**WELWYN HATFIELD BOROUGH COUNCIL  
EXECUTIVE DIRECTOR - PLANNING, PUBLIC PROTECTION AND GOVERNANCE**

**Application No:** 6/2019/1874/HOUSE  
**Location:** 64 Gorseway Hatfield AL10 9GS  
**Proposal:** Erection of single storey rear extension  
**Officer:** Mr A Commenville

**Recommendation:** Granted

Drawing No: 4744-P01 Revision: A

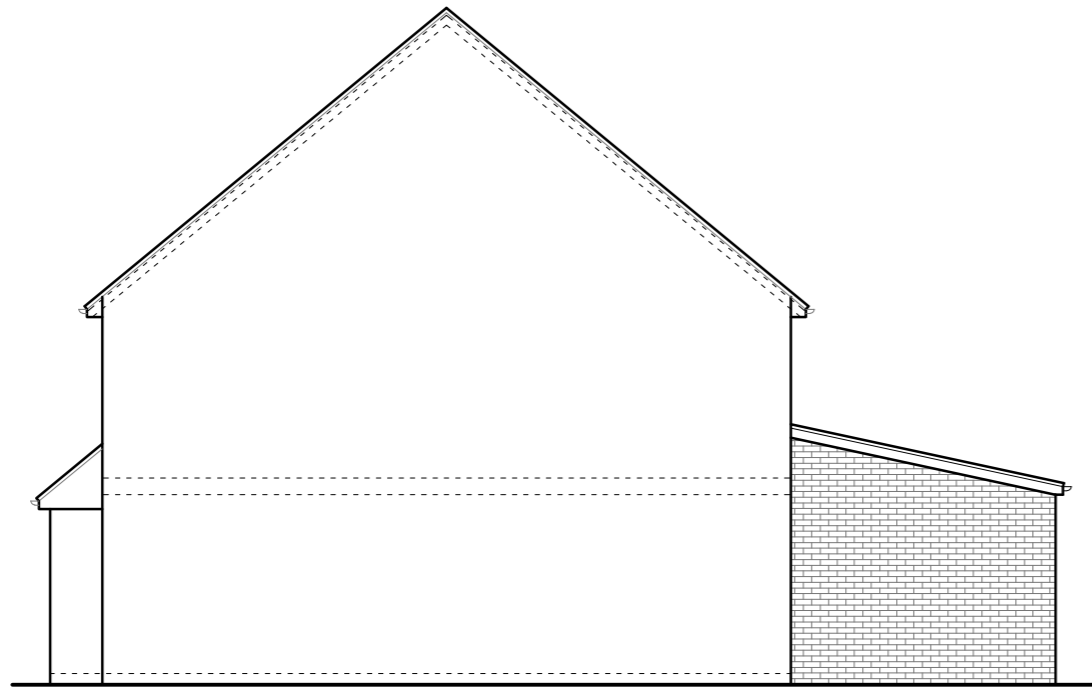
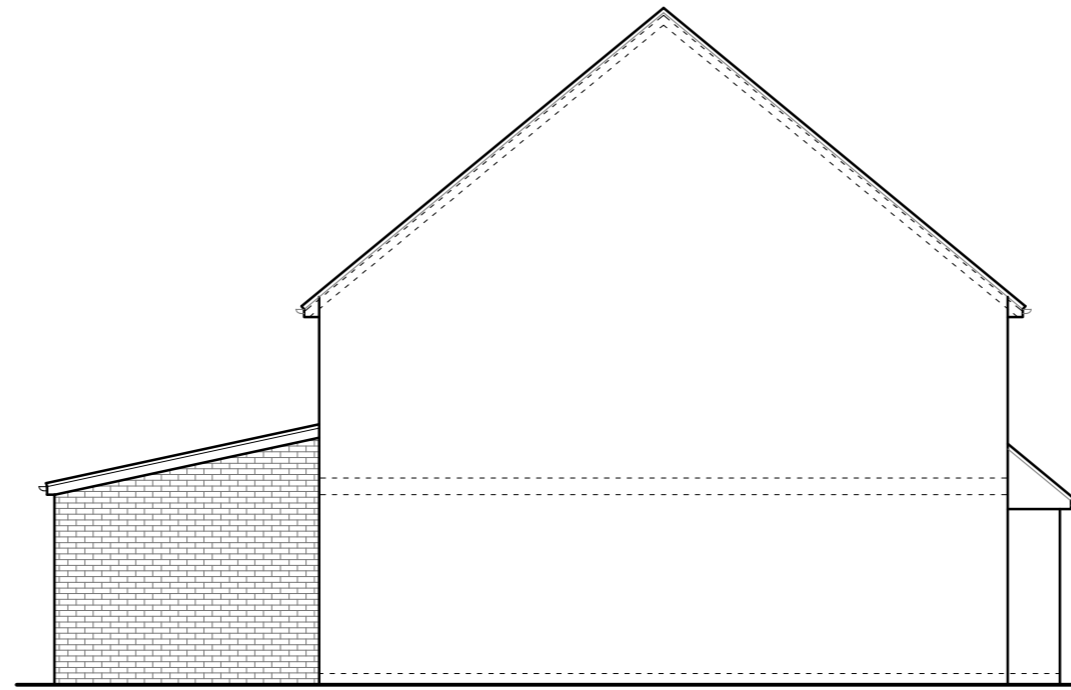
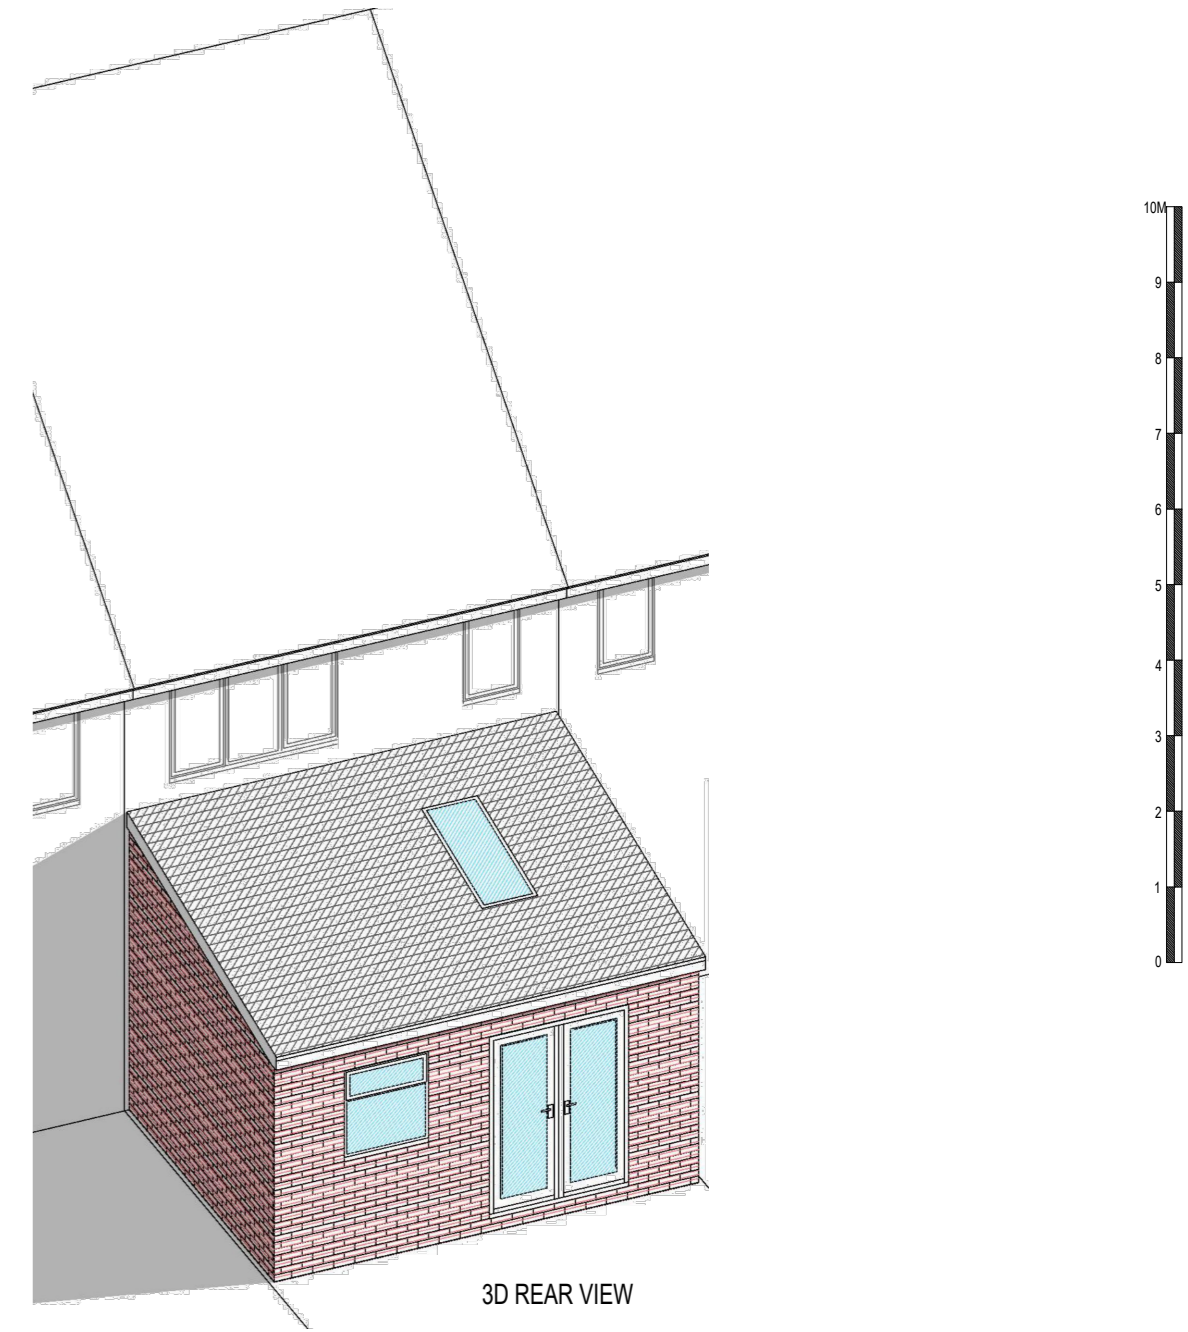
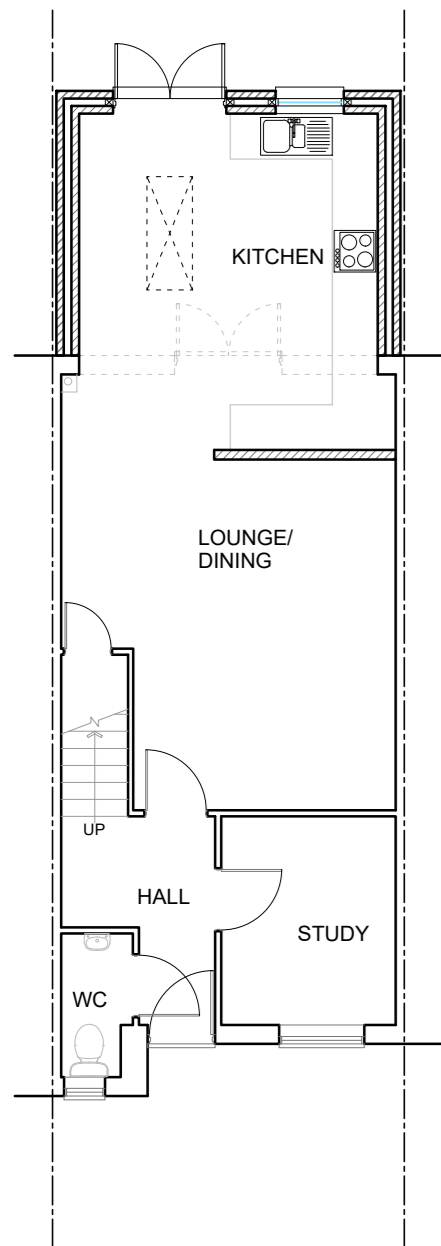
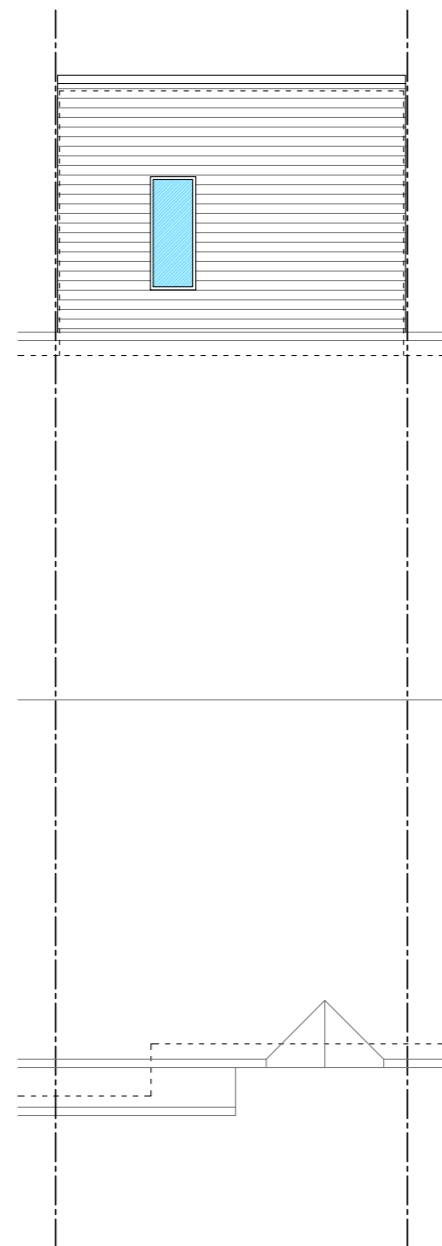
**Comment** (if applicable): The comments and concerns received from the neighbouring property at No.62 Gorseway with regard to the loss of light are noted. This extension, by virtue of its height, depth and proximity to the shared boundary would inevitably cause loss of light to that currently afforded to the ground floor windows of No.62 and also would have a more dominant impact.

While the proposed extension would measure 3.5 metres in depth, it would have a mono pitched roof measuring 2.5 metres at eaves level and 3.4 metres at its top. It is noted that if the application site benefits from its permitted development rights, a rear extension under permitted development could be erected and measure 3 metres in depth but up to 4 metres in height and 3 metres at eaves level. Having regard to this and having regard to the scale, siting and height of the proposed extension, it is on balance considered that the proposed extension would not have such degree of harm upon the amenities of neighbouring occupiers at No.62 or No.66 Gorseway to justify the refusal of planning permission.

It is noted that this neighbouring property commented that the single storey rear extension would be very close to the boundary fence. Any impact on the fence is a private matter that should be discussed between the neighbours and is not a planning consideration. An informative has been added in this regard.

In light of these observations, the proposal is considered to be acceptable in this regard and so complies with Policy D1 of the District Plan, the Design Guide SPG and NPPF.
